Subject: RE: FRA report - comments from planner for MM

Further to your email this morning and also refer to previous emails and discussions between us, yourself and Alex Fraser. This proposed mixed use development is considered to be 'more vulnerable' development under the NPPF. We have identified the following issues with the submitted documents and the assessment of flood risk which require further clarification:

LOWER GROUND FLOOR PLAN

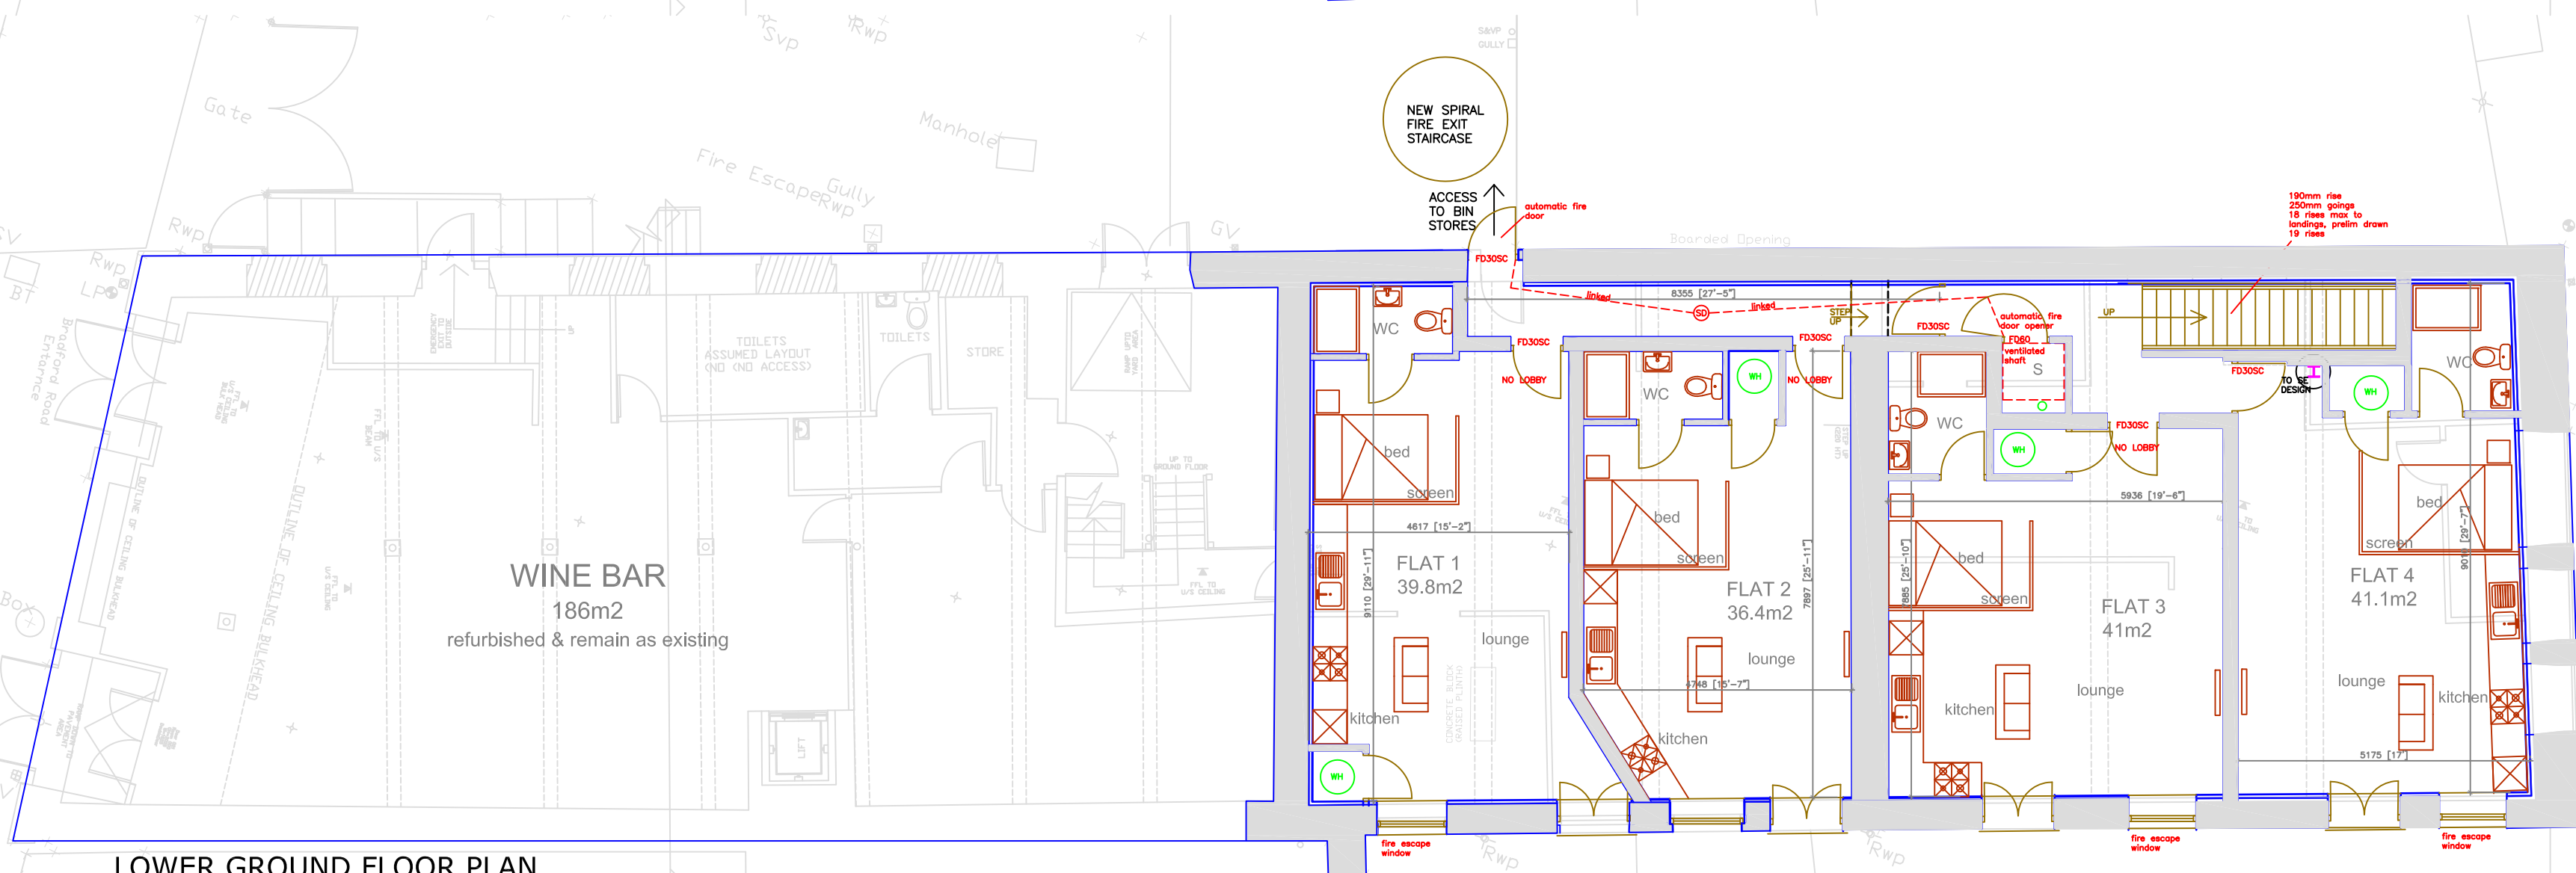
- We note two of the lower ground floor flats access an upper floor safe refuge via an external spiral stair case which requires occupants to leave the building at ground level to access this in the alley way. The FRA should consider the flood risk associated with this access and whether internal access might be possible for the flats on the lower ground floor. The FRA should consider any flood risk associated with the ground floor access/egress onto Station Road and if any mitigation is required, and likewise from the wine bar onto Bradford Road.

EAST FACING ELEVATION
STATION ROAD

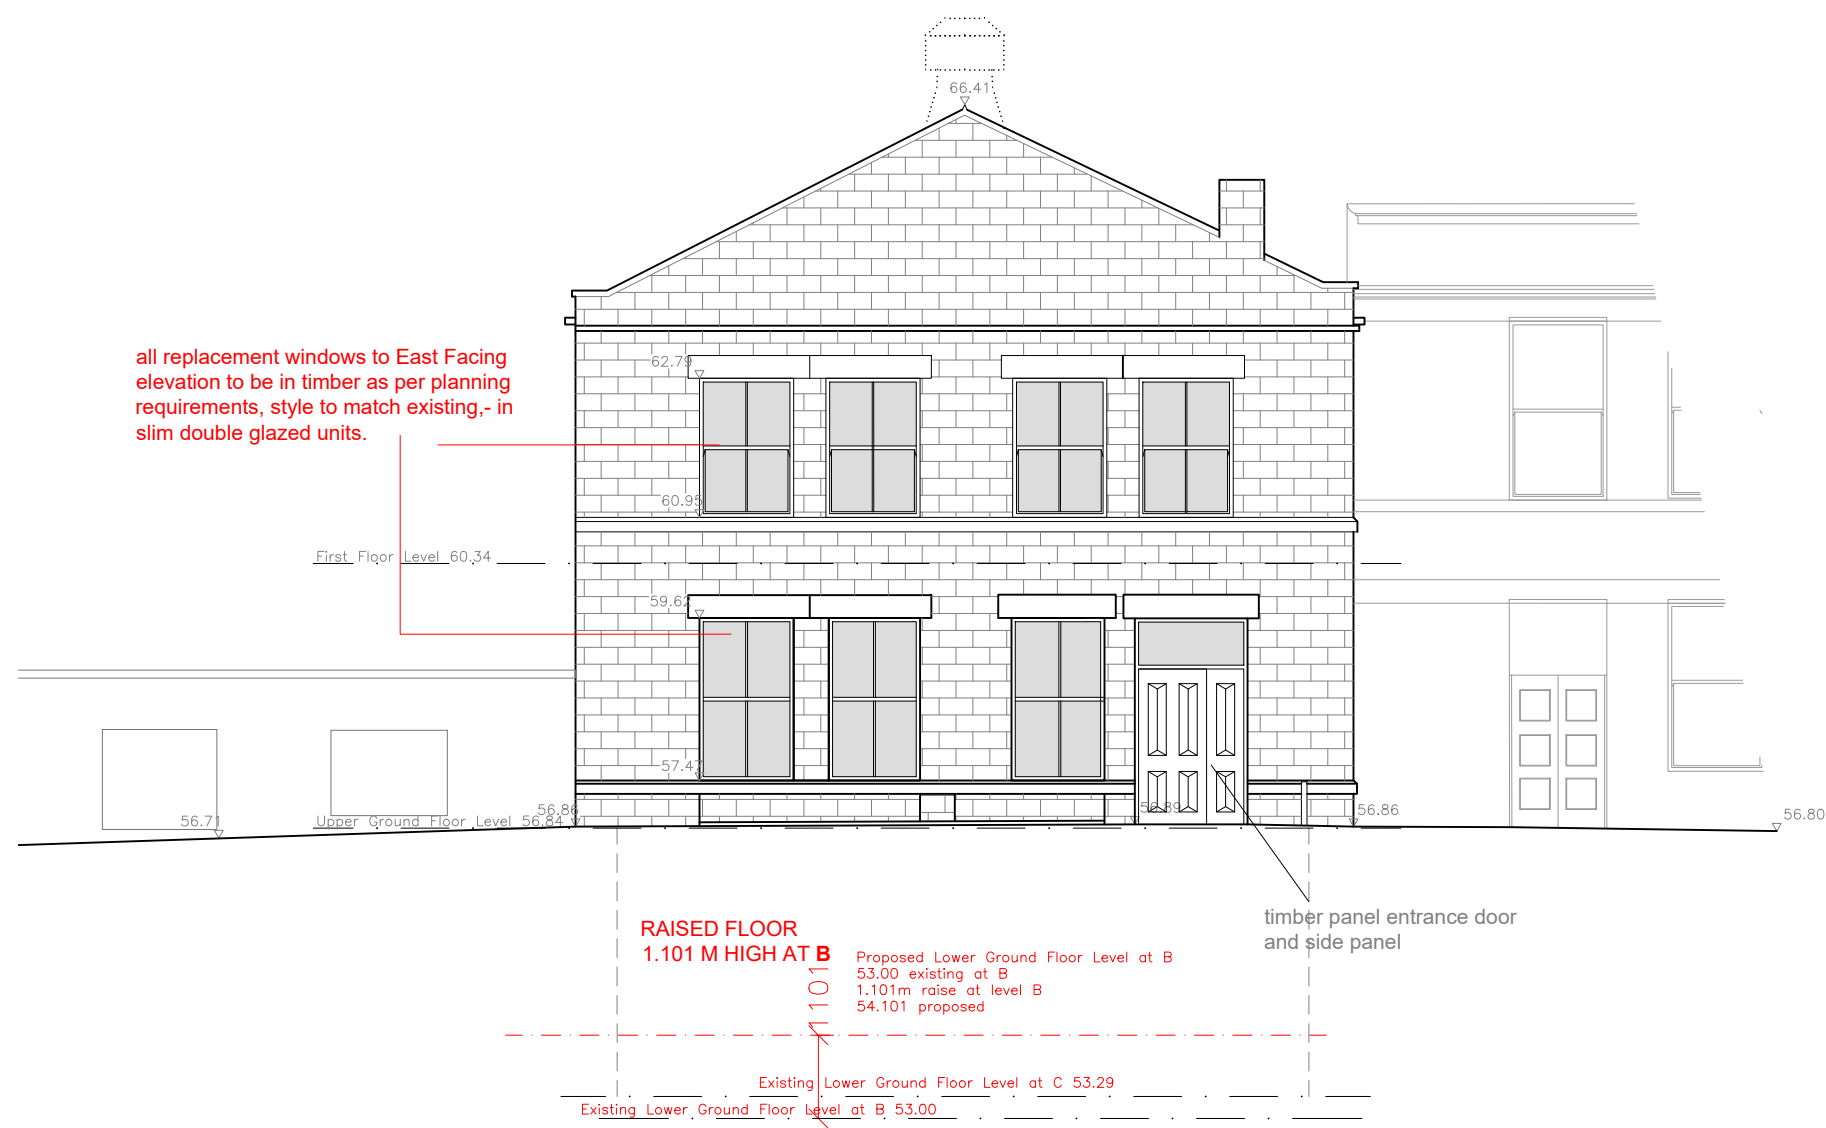
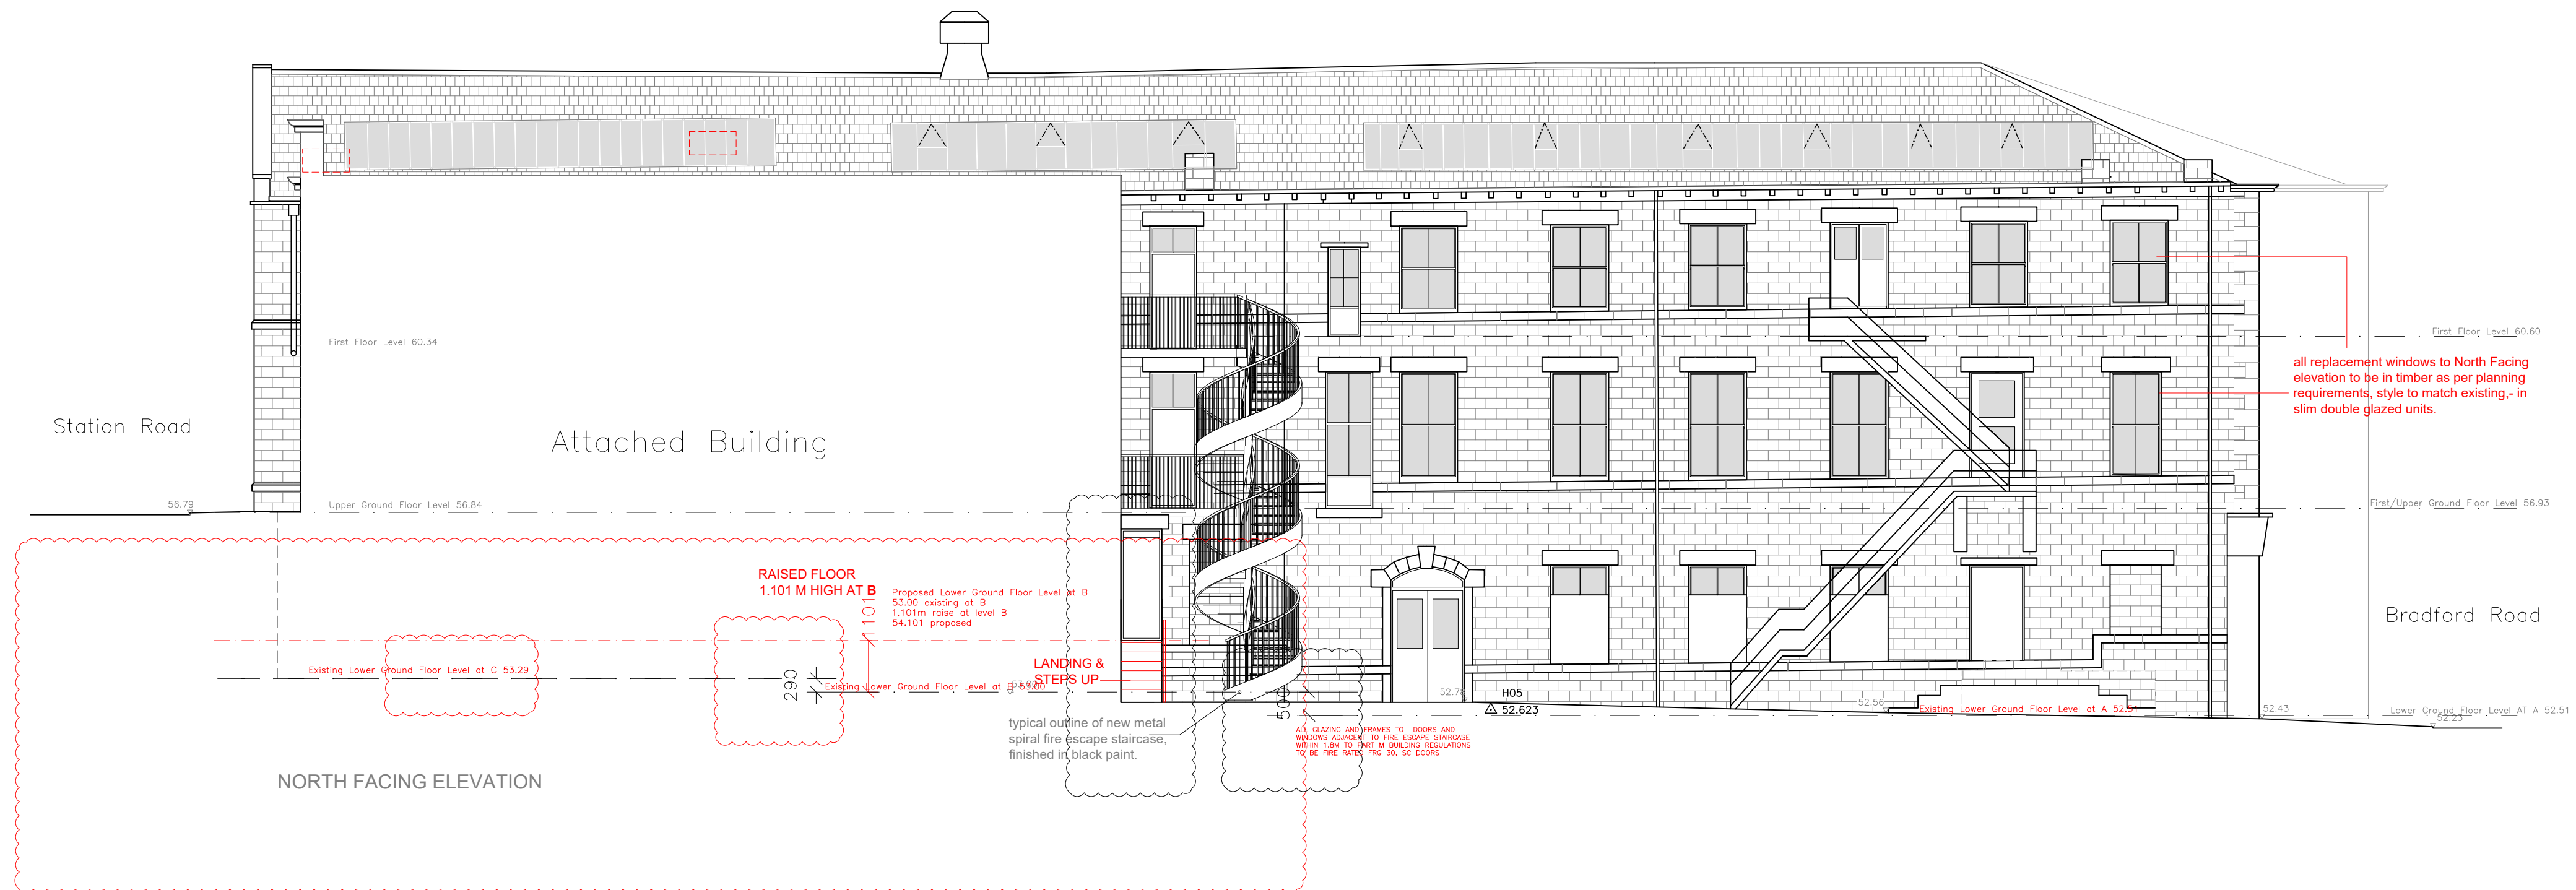
- There are a number of discrepancies on the elevation drawings showing differing finished floor

levels which need to be clarified. For example, in the lower ground floor flats where the 1m finished floor level raising is proposed, the level appears lower than one of the existing FFLs. We note that the road level on Bradford road is considerably higher than the wine bar FFL, however it is not clear whether this could be an error in the OS base mapping.
